28 May 2013

**Re: Exhibition of Mainfreight Dangerous Goods Storage Facility at 30 – 50
Yarrawa Street, Prestons**

Tanya O'Brien
Manager Strategic Planning

### Truck Parking Management Plan

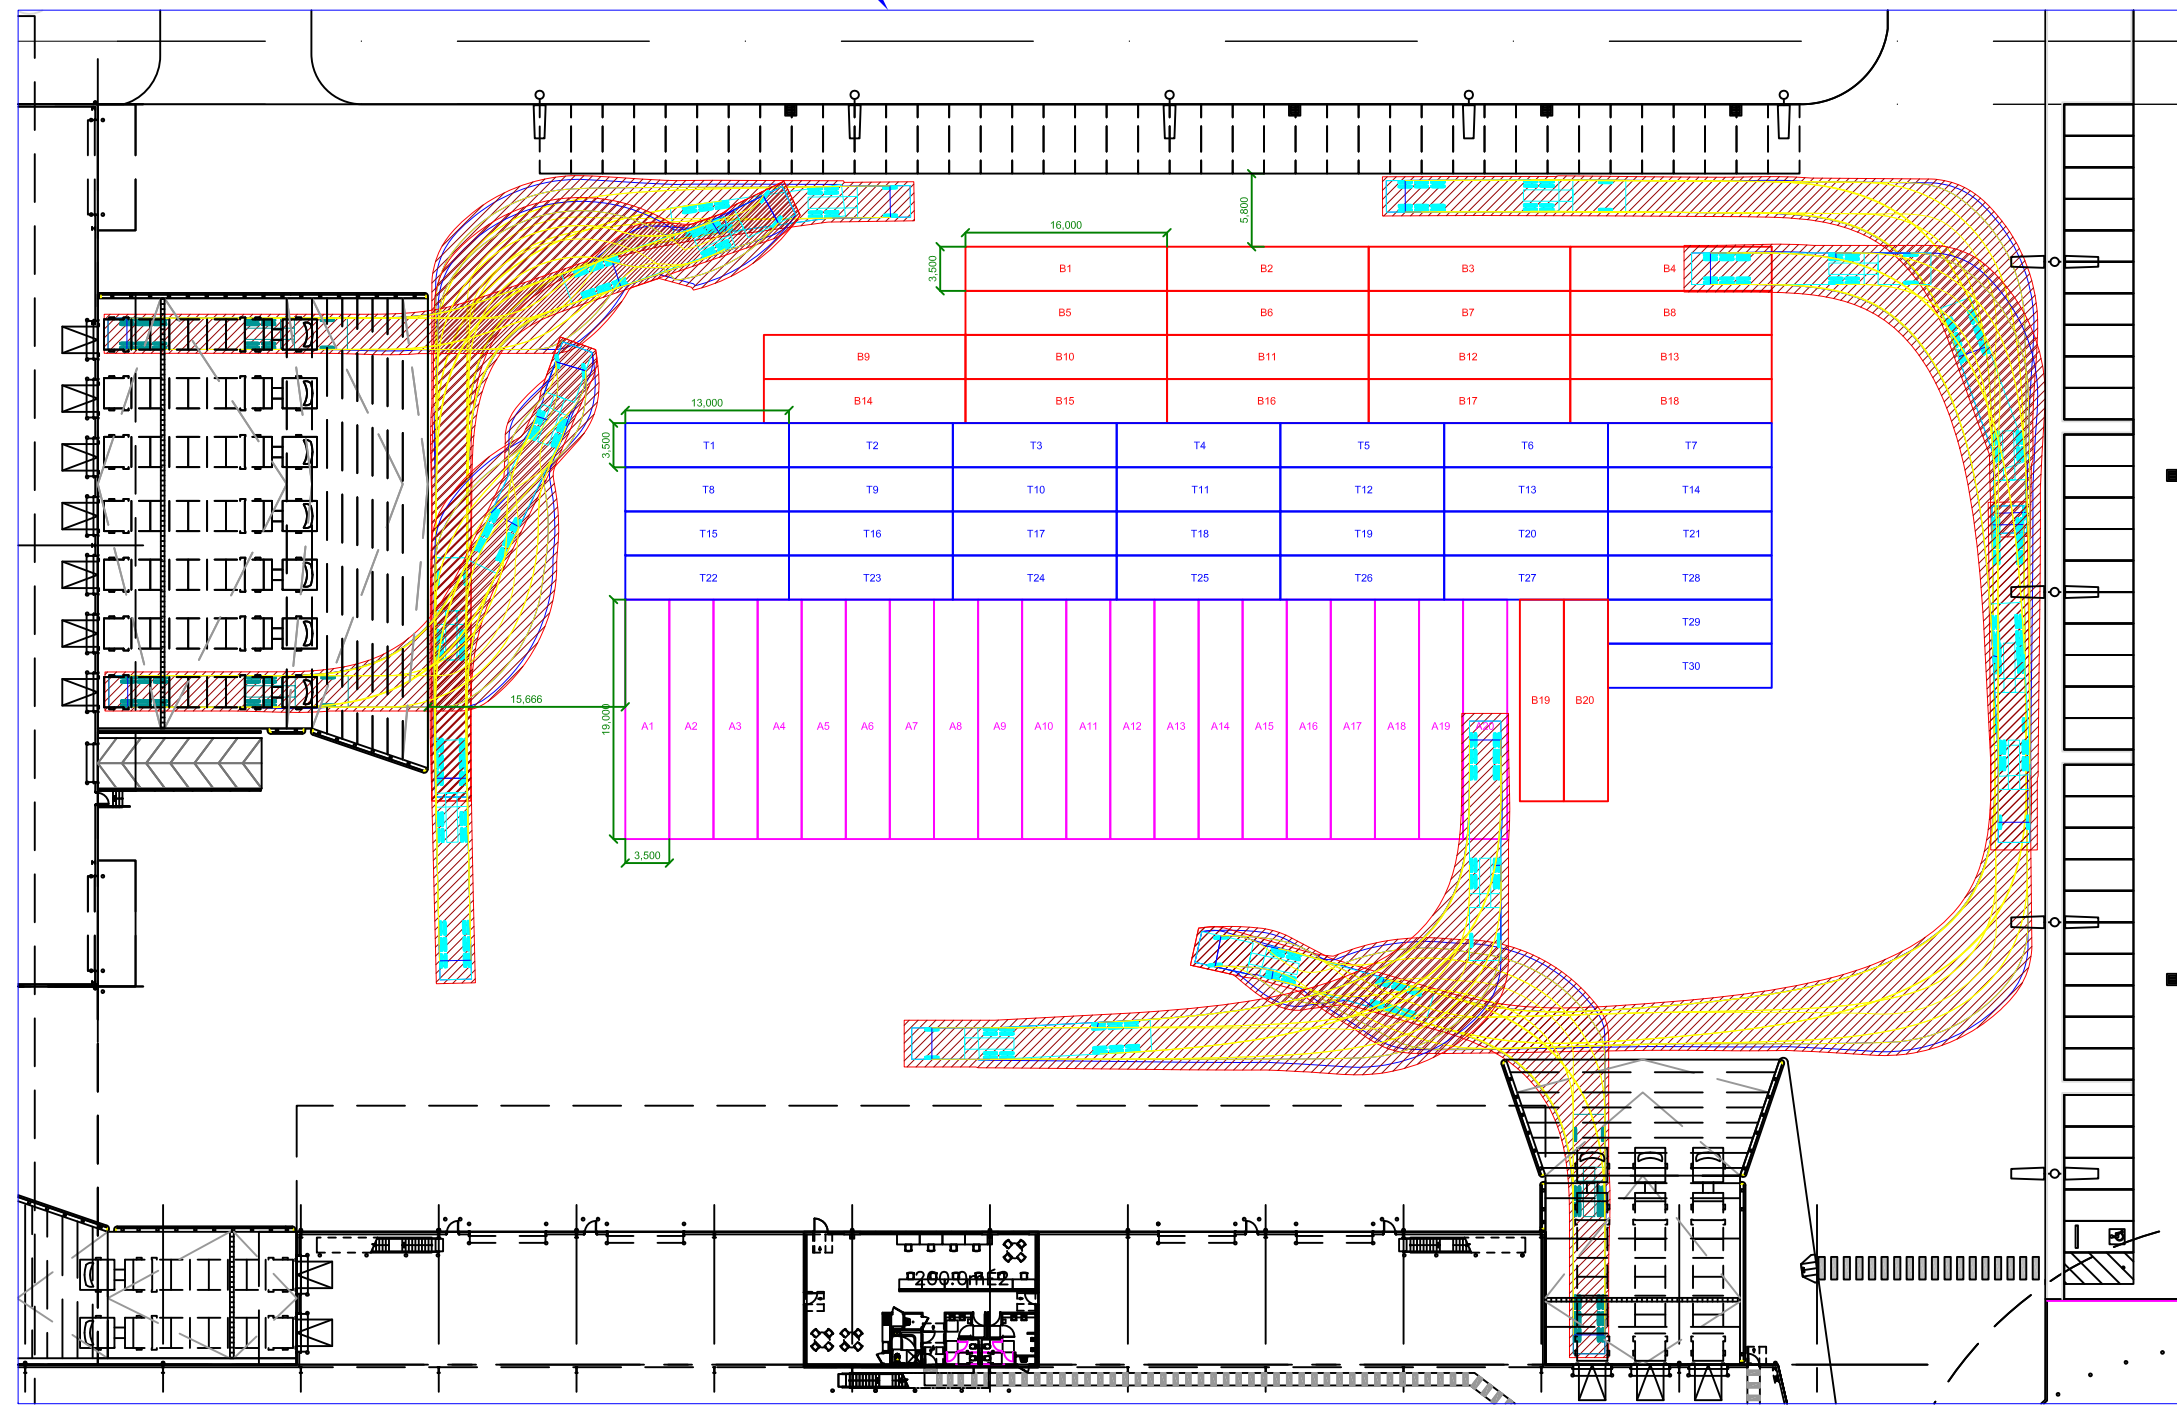
- The plans currently available to Council do not demonstrate that the internal layout of the site is able to accommodate all the trucks that would be required to be stored at the development site. The developer should be requested to demonstrate how this can be achieved.

2. Storage of trucks. Developer to provide information that appropriate provision has been made on site for the storage of all trucks that would need to park at the development site. No Parking is to be permitted for storage trucks along Yarrawa Street.

Swept Path Analysis

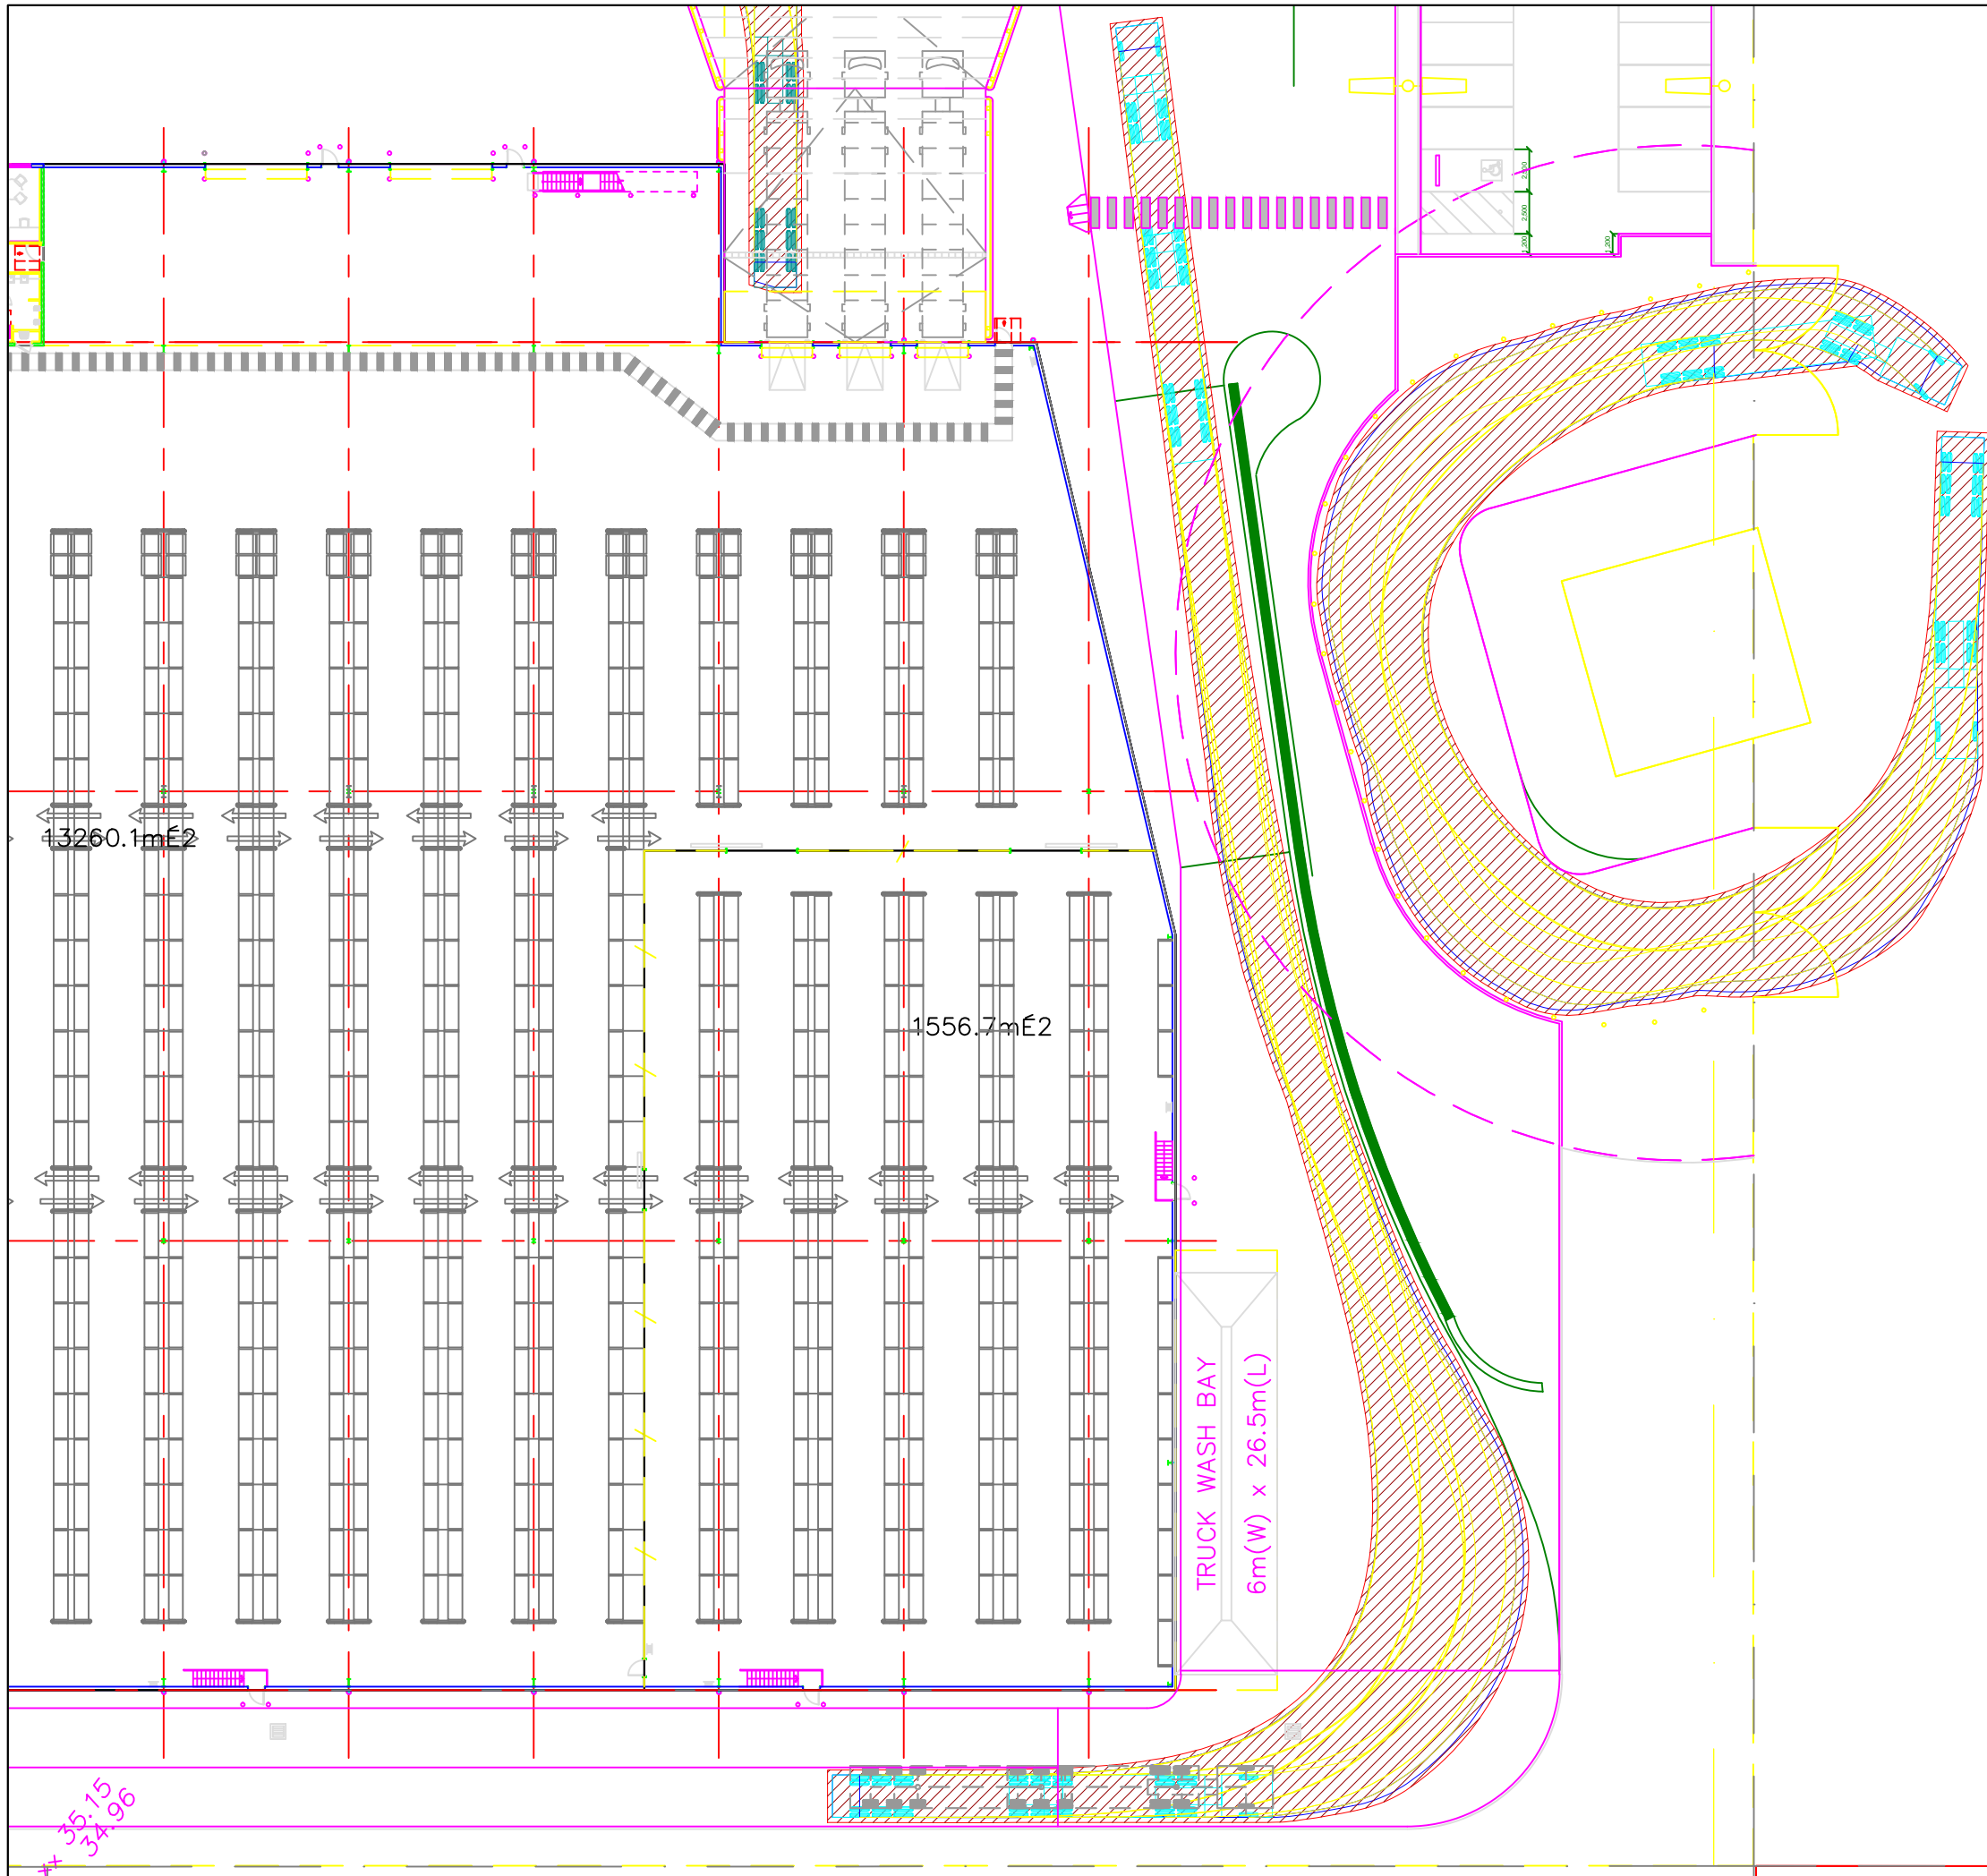
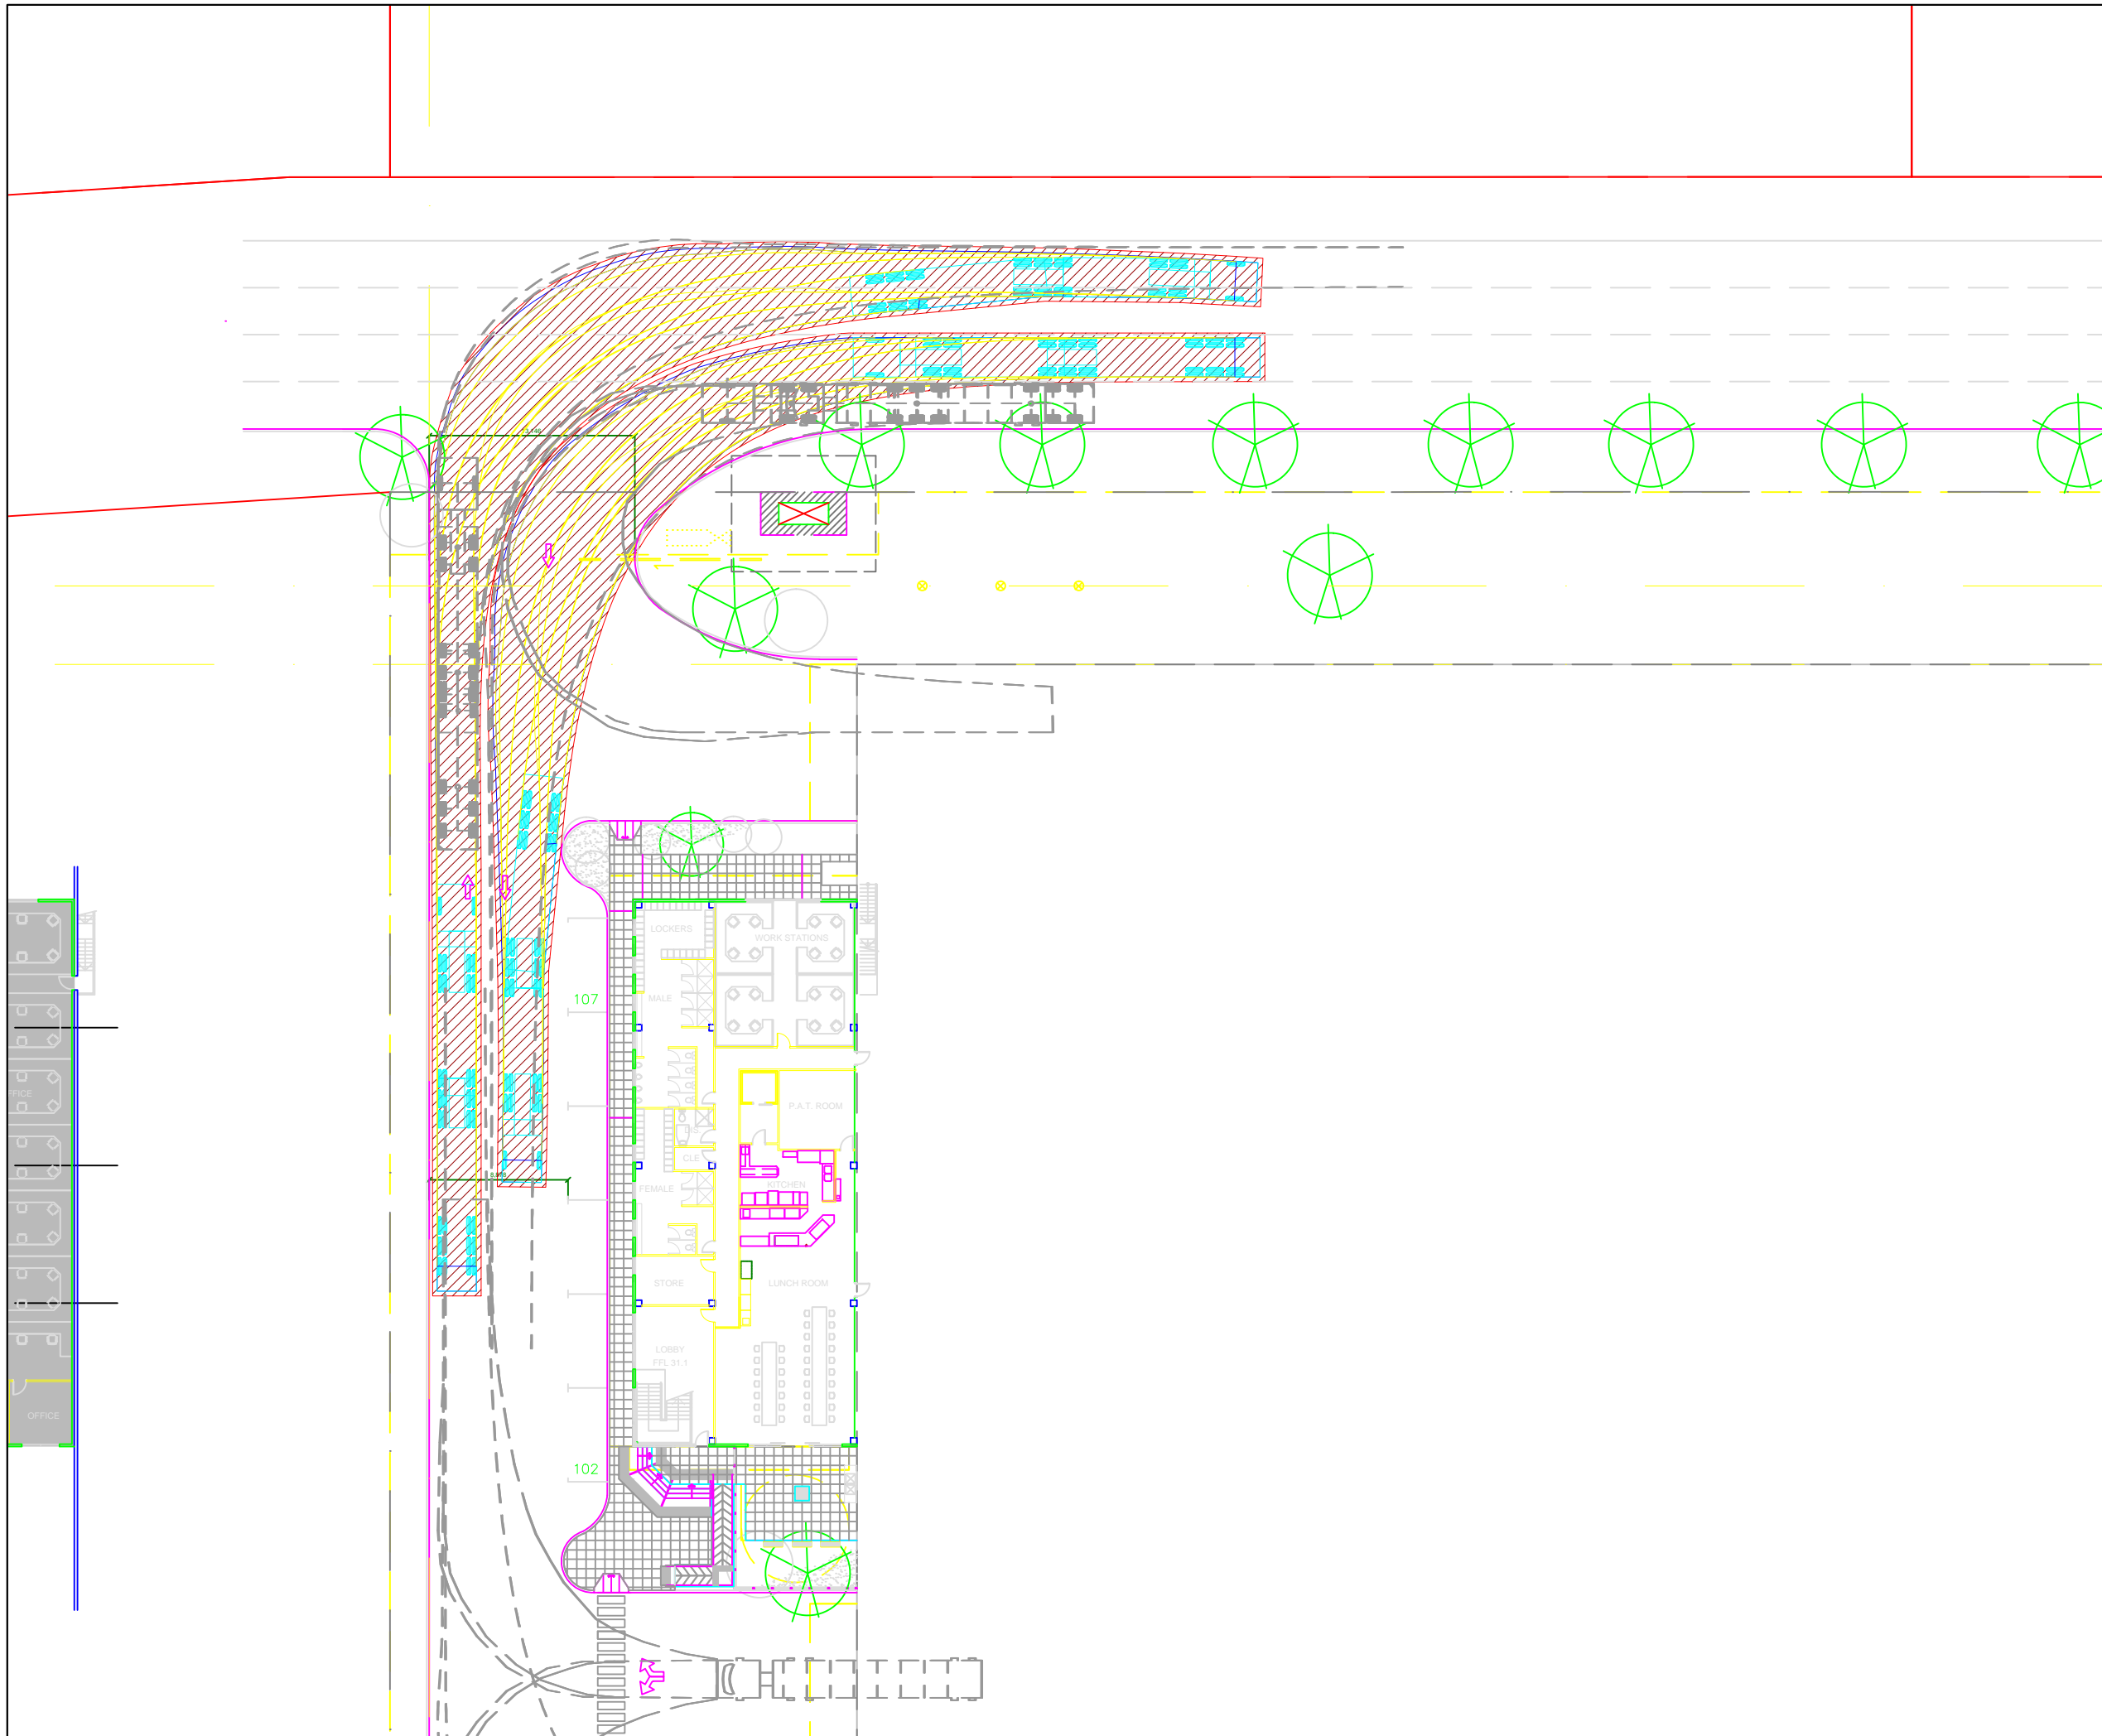
- The internal layout and proposed driveways for staff parking as well as the heavy vehicles are to be in accordance with Australian Standard AS2890. The driveways for the heavy vehicles for the B-double trucks are to ensure that they can accommodate the swept path of a 26m B-double.

3. Truck parking swept path. A layout demonstrating the truck storage can accommodate the swept path of a 26m B-double and also ensuring that such trucks can enter and leave in a forward direction.
